0485SYD - Ltr2481-19

**SYDNEY MODERN PROJECT: ART GALLERY NSW
\$4.55 COOLING TOWERS MODIFICATION RFI (SSD 6471)**

In response to the Request for Information (RFI) received from the City of Sydney Council (Council) dated 16 July 2019 and Heritage Council of NSW dated 5 July 2019 please see responses relating to trees and landscaping below:

**Sheet Title**  
**Cooling Tower Corner**  
**Sheet No.**  
LD\_DA\_00-17

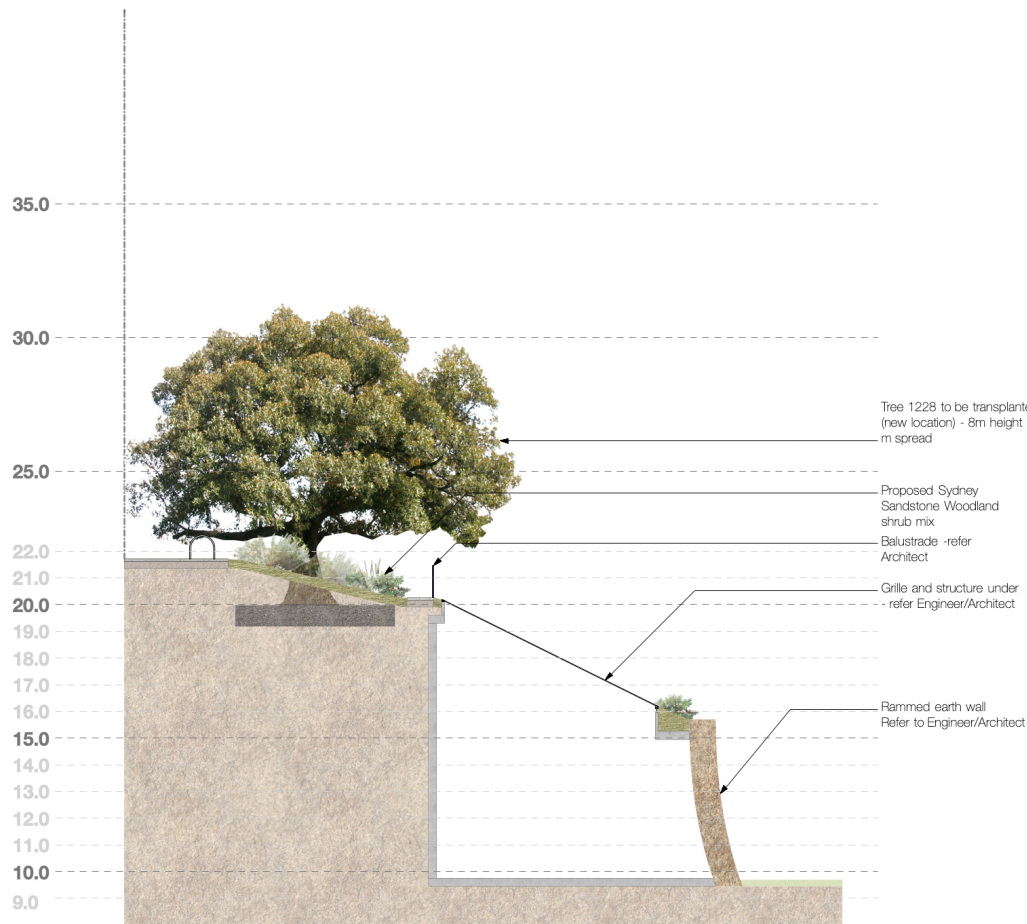
- There are no shrubs located directly on top of the cooling tower grille. The health of surrounding vegetation is not expected to be impacted by the release of warm air from the grill. The proposed landscaping surrounding the grill will screen the grill from the public domain to ensure visual amenity.

- Proposed new trees located adjacent to the cooling tower grill will be offset a minimum of 1.5m away from the edge of the grill, which is a sufficient distance to ensure that the tree's canopies are not impacted by the release of warm air from the grill. Trees surrounding the grill are native Australian species which are heat tolerant and will not be impacted by the maximum air temperature difference of 5-6 degrees directly adjacent to the grill.

- Existing tree T1118 is 12.7m away from outer tree trunk to the edge of grill while T1228 is 4.5m away. They are not expected to be impacted by the warm air released from the grill.

- Existing tree T1228 is sitting within 6x6m root plate as part of the transplanting process, no further excavation is required as part of the new path and cooling tower footprint.

- The intrusion of the cooling tower footprint into the T1118 tree protection zone has been signed off by the arborist (Refer "AGNSW_AIAR_ADD5_v3x");
- Please refer to updated landscape plan and sections "LD_DA_00-17" and "LD_DA_20-01" for further information.

2 Section B  
Scale: 1:100

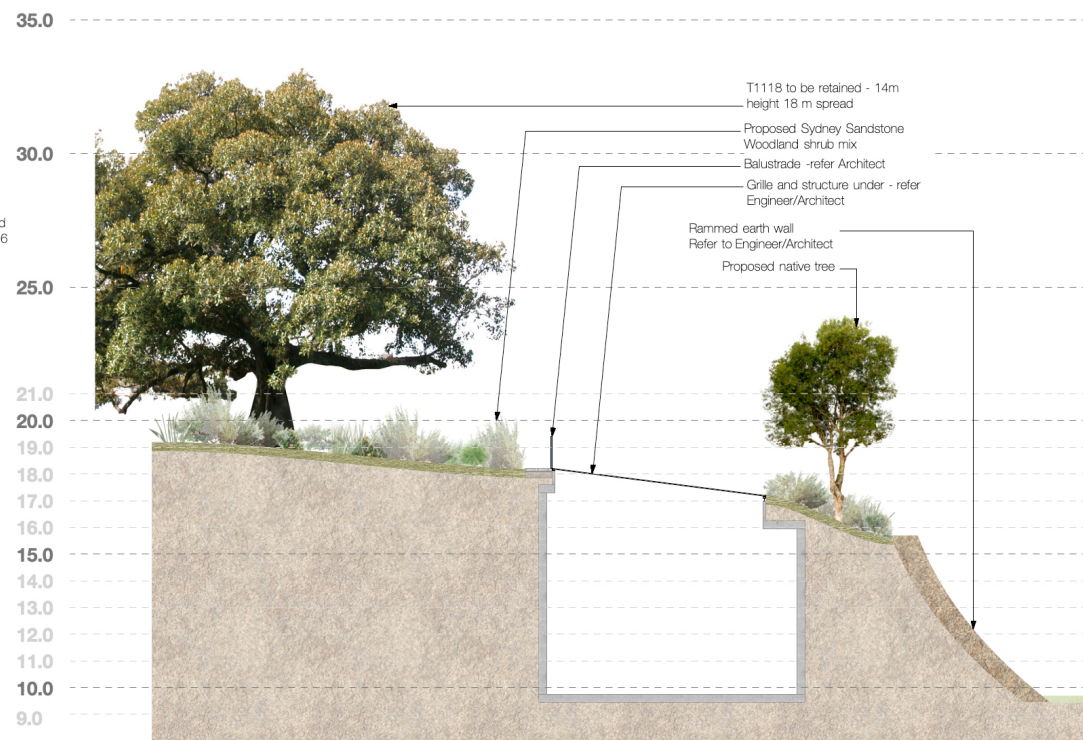
- Air flow through the grille is approx. 50-70m³/s at full load (max flowrate). The max air velocity is calculated to be approximately 2m/s (around 7km/hr). This air flow velocity is not considered to be significant enough to impact the long term health of the surrounding vegetation;
